# CITY OF ALBUQUERQUE

**Re: Presbyterian Hospice Facility**  
**6000 Forest Hills Drive (E18-D005C)**  
**30-Day Temporary Certificate of Occupancy**  
**Transportation Development Final Inspection**  
Engineer's/Architect's Stamp dated 02-23-2021 (E18-D005C)  
Certification dated 06-16-2022

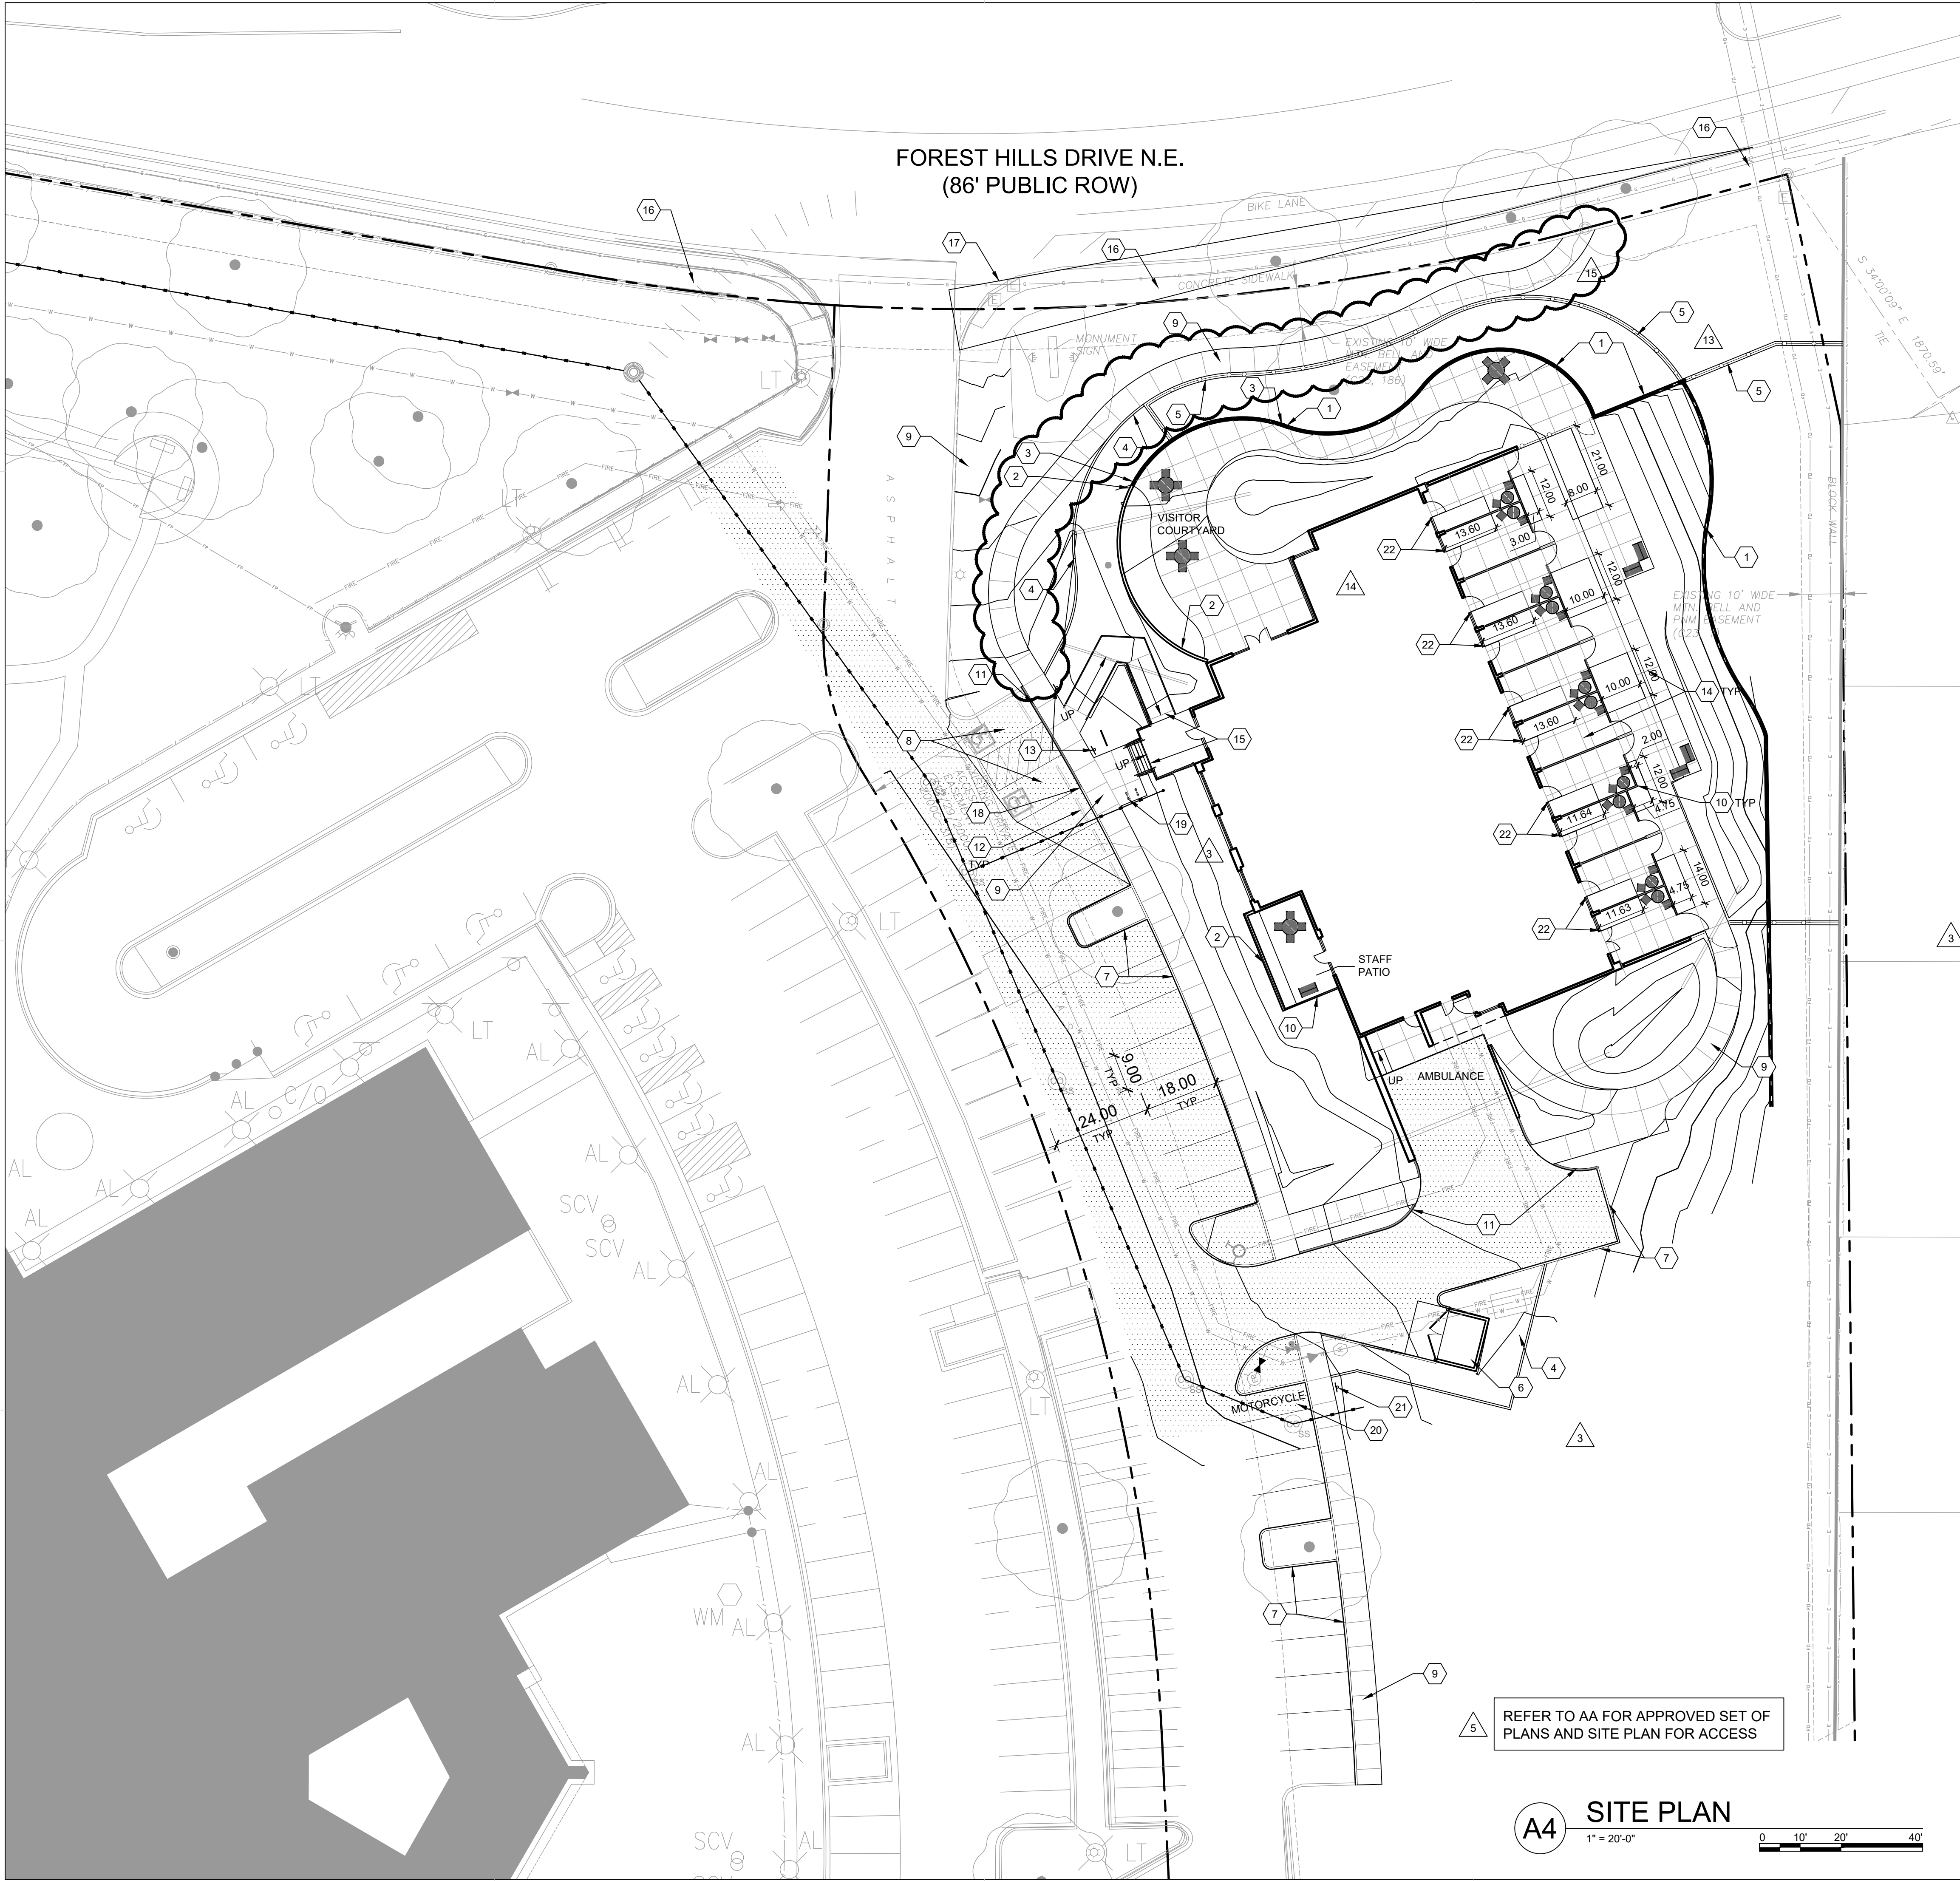
- Remove surrounding fencing and clean site.
- Place fill around handrail posts for ADA ramp to building for stability.
- Revise drawing to show new sidewalk configuration layout which would not include the proposed sidewalk to the right-of-way. There had been previous discussion about finding an alternate route; if infeasible due to topography/existing conditions, request waiver to this requirement.

Include pictures once completed for a permanent Certificate of Occupancy, and revised drawing. If you have any questions, please contact me at (505) 924-3991.
